**Subject: Carriage Meadows North at Lorson Ranch Final Plat (SF 17-023)**

The Planning Division of the Community Services Department has reviewed the development application for Carriage Meadows North Filing No. 1 Final Plat and has the following comments of behalf of El Paso County Parks. These comments are being provided administratively as this application does not require Park Advisory Board consideration. This application was reviewed by the Park Advisory Board on December 13, 2017 and was endorsed with the following recommendation:

FINAL PLAT
CARRIAGE MEADOWS NORTH
FILING NO. 1
JOB NO. 70-055
DATE PREPARED: 12/06/2017
DATE REVISED: 01/29/2018

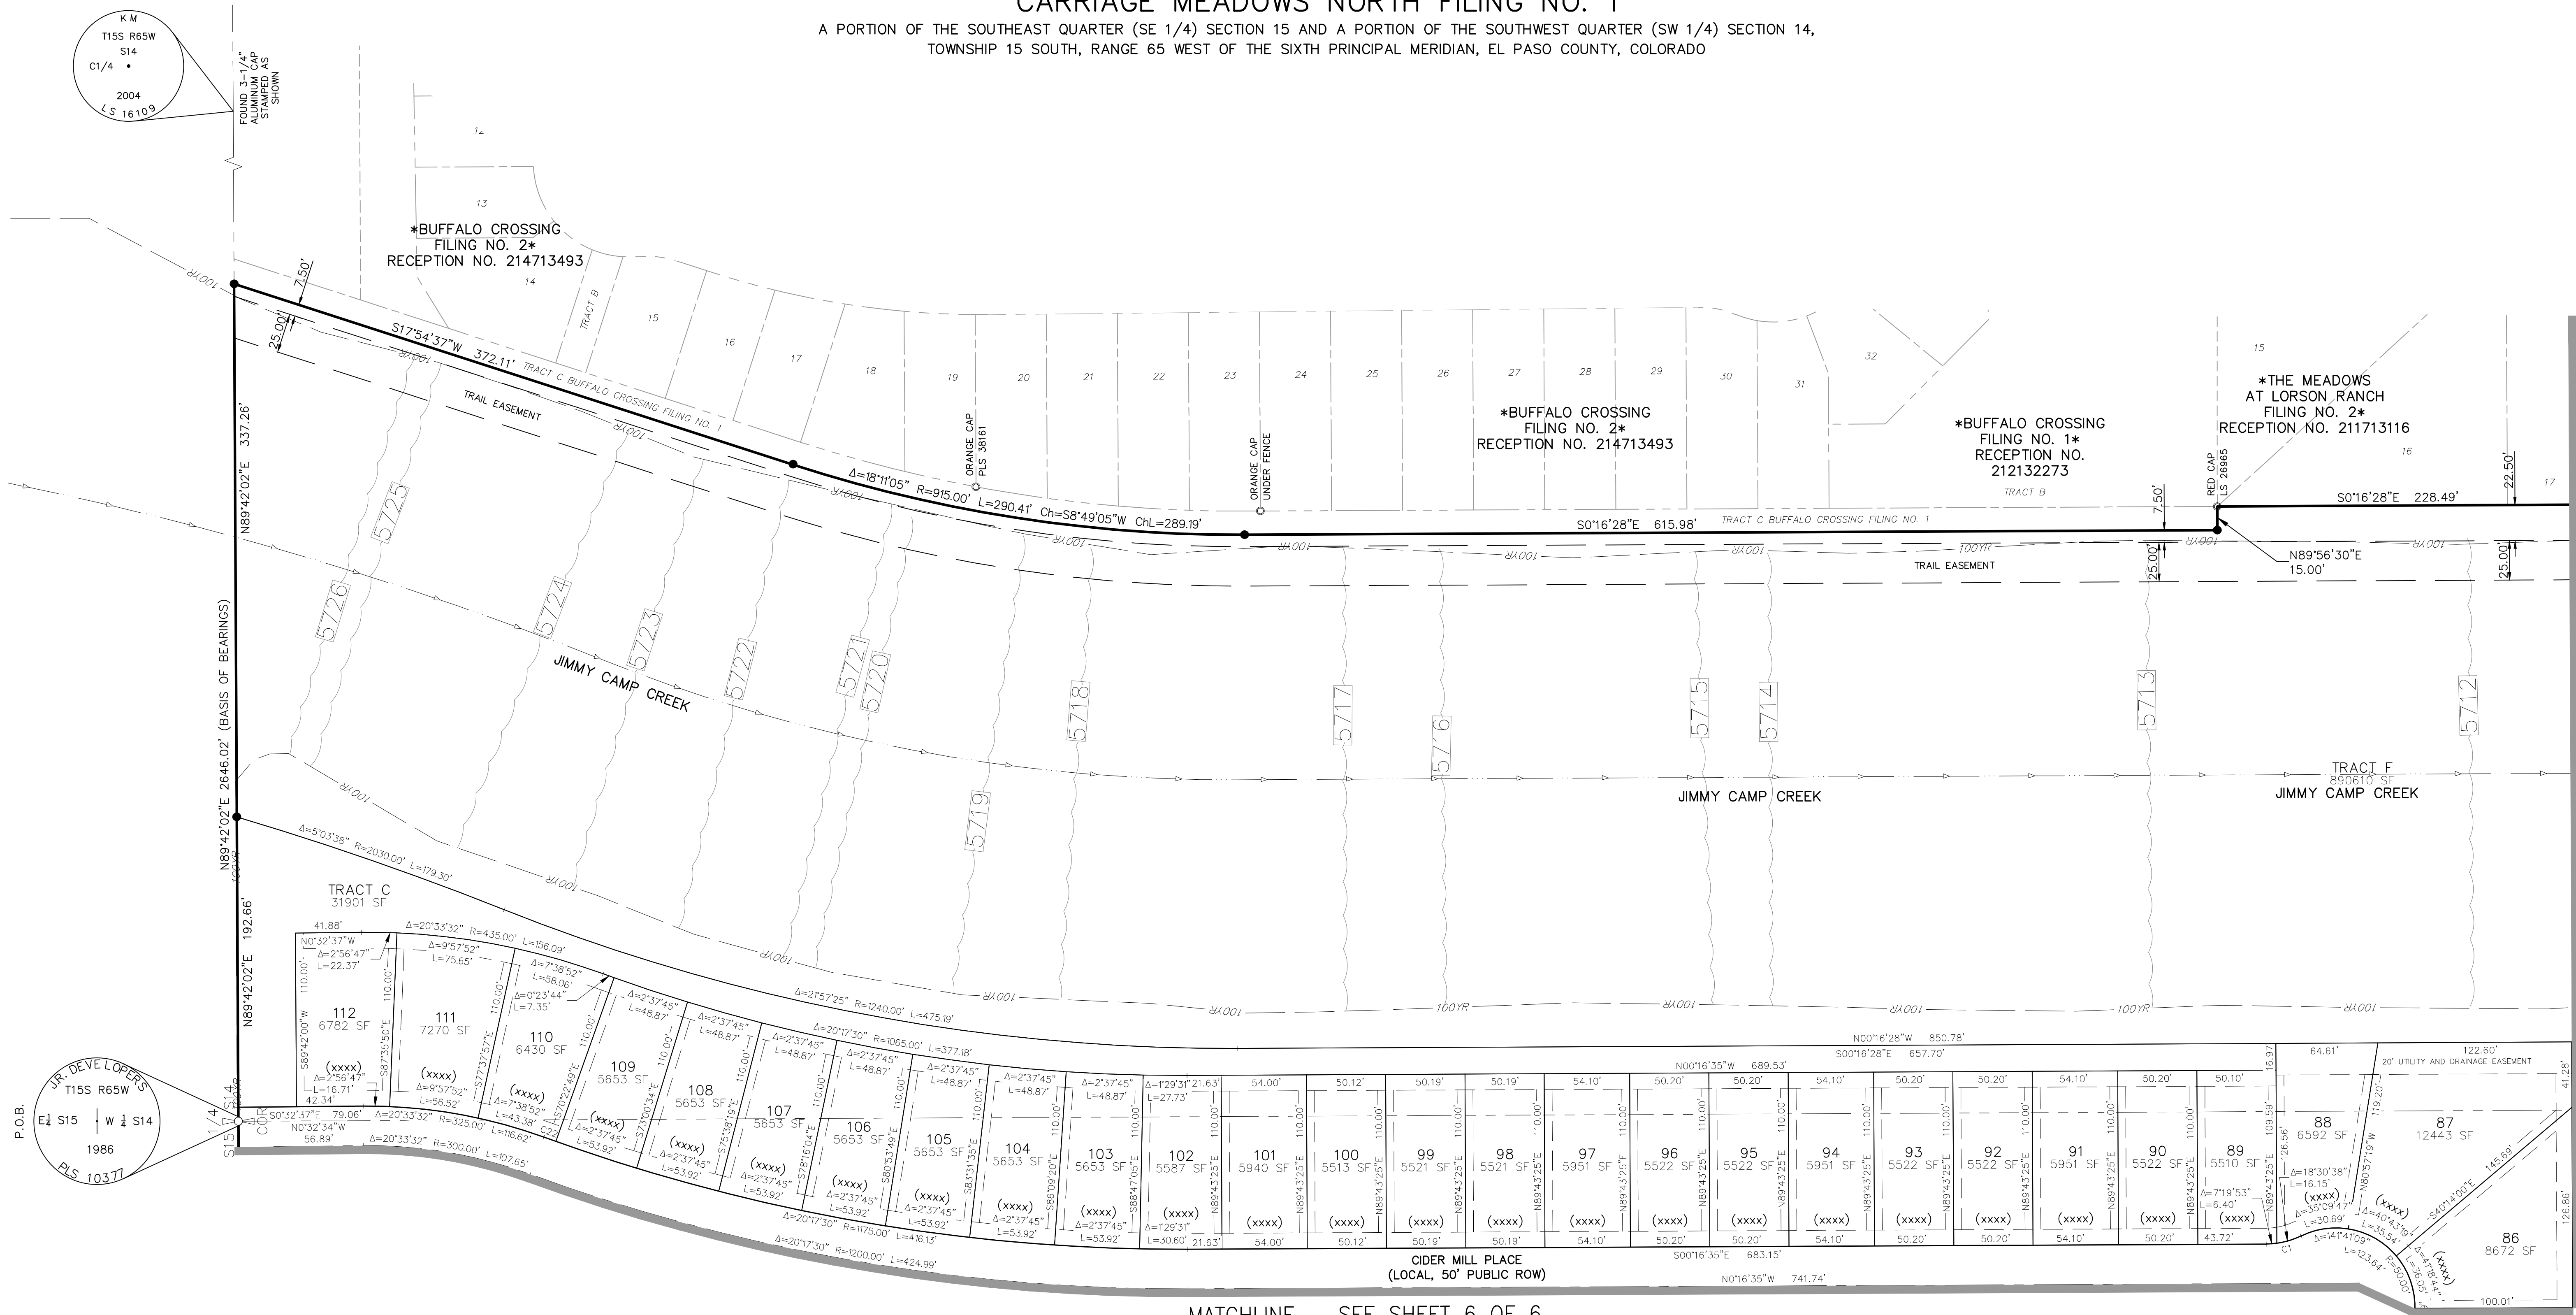
*Recommend to the Planning Commission and Board of County Commissioners that approval of Carriage Meadows North Filing No. 1 include the following conditions: (1) Meet the open space dedication requirements for PUD zoning by providing 10% of the site as open space (2) Correct the tract table on the final plat drawings (3) Require fees in lieu of land dedication for regional park purposes in the amount of \$66,650 and urban fees in the amount of \$42,106.*

There are several discrepancies within the letter of intent regarding total subdivision size, tracts, and open space dedication. This does not match the tract table shown on the drawing and needs to be revised. For purpose of this review, the information contained within the letter of intent will be referenced.
